RE: Harvard Apartments
214 Harvard Drive SE
Grading and Drainage Plan
Engineer's Stamp Date: 05/25/2022
Hydrology File: K16D095

Based upon the information provided in your submittal received 06/13/2022, the proposed Grading and Drainage Plan is not approved for Building Permit. The following comments must be corrected prior to approval.

GRADING AND DRAINAGE PLAN

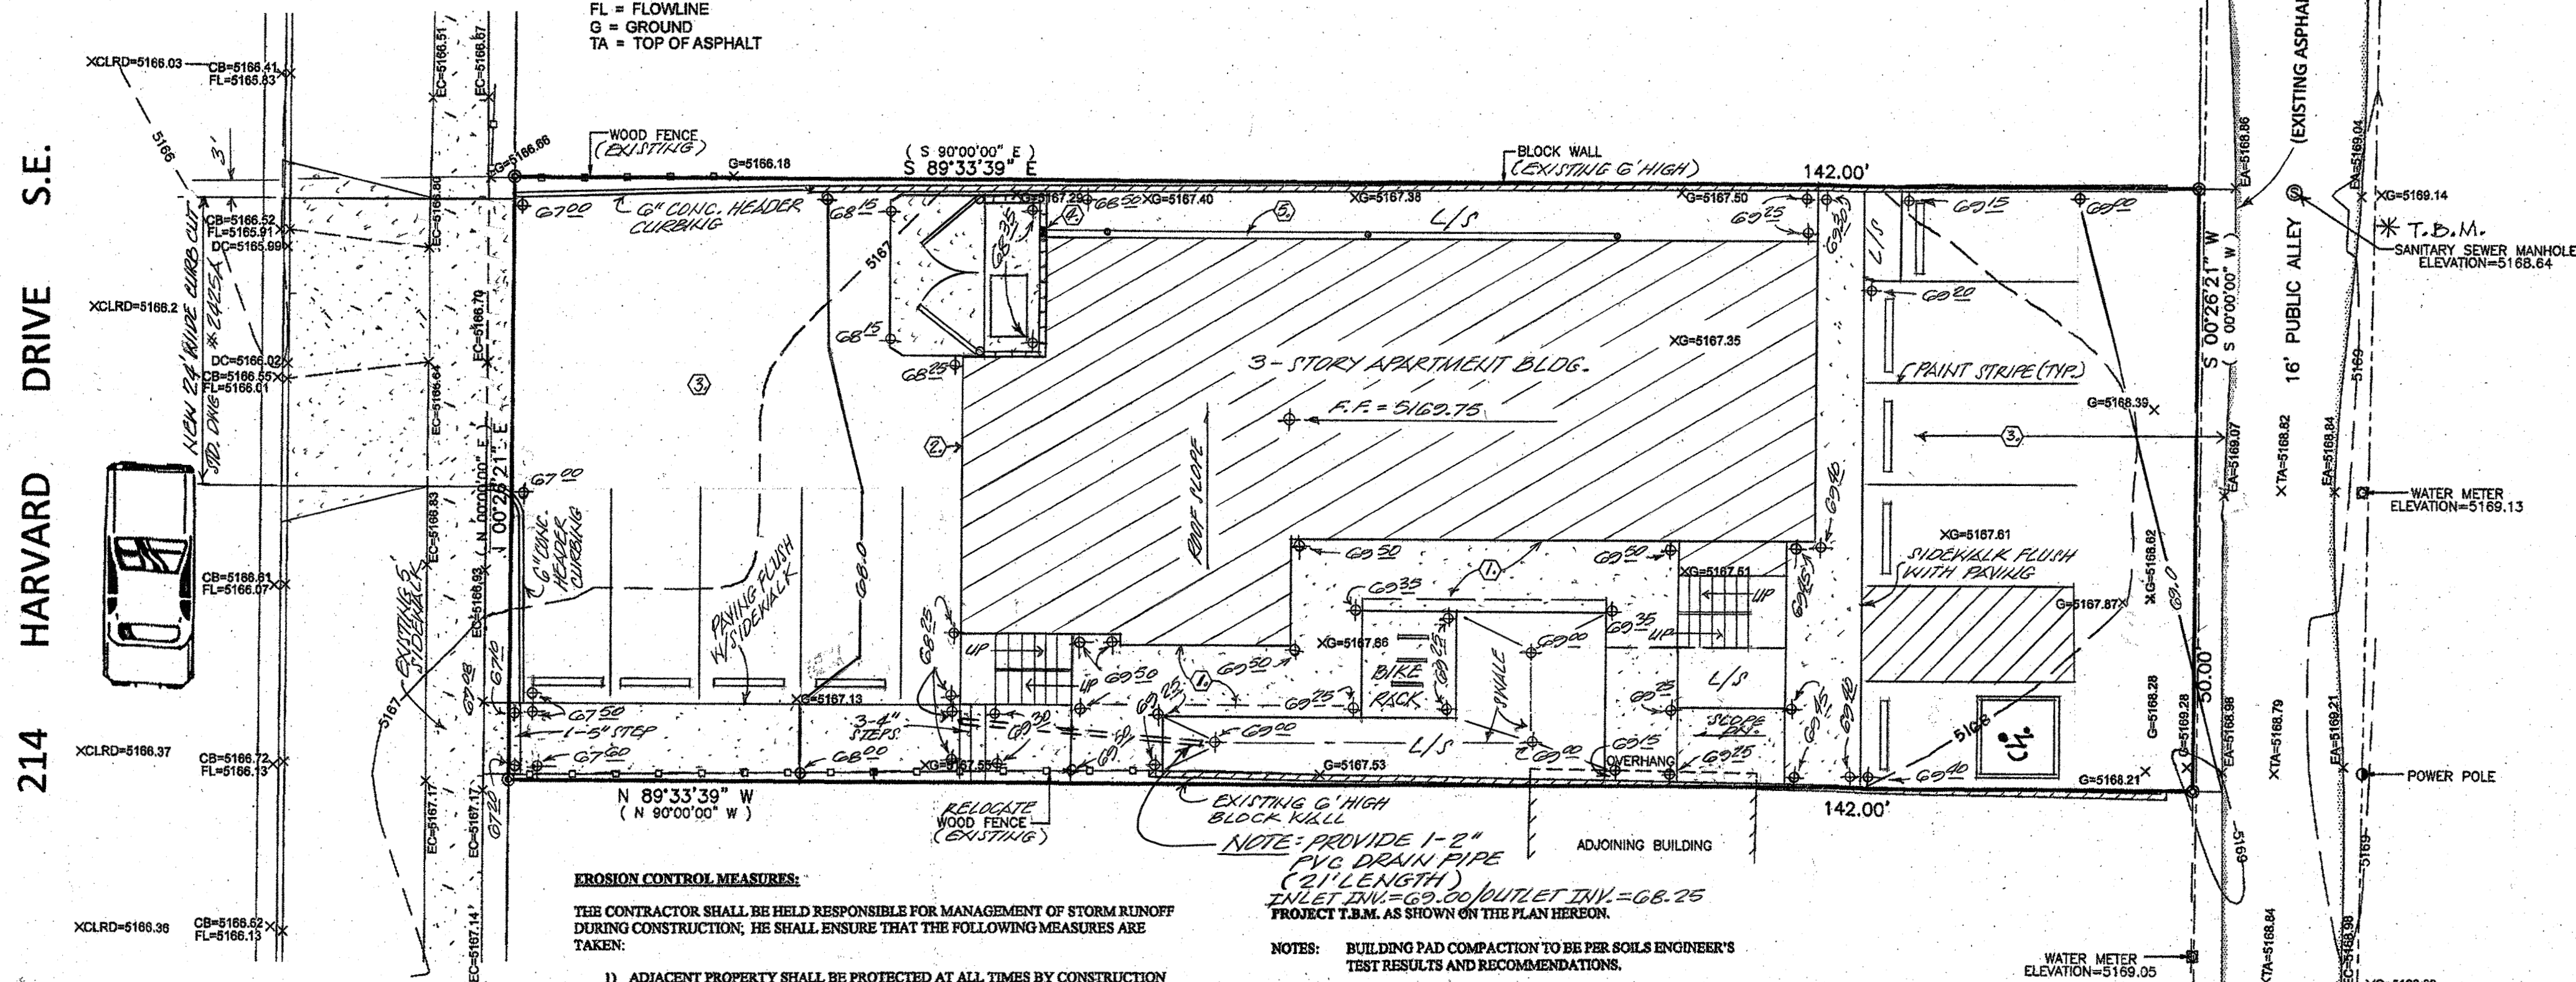
1. Please include some storm water quality treatment.
 - a. There is potentially area where your proposed swale is.
2. Please delineate the basin split.
3. Please clearly call out existing vs proposed contours in a legend.
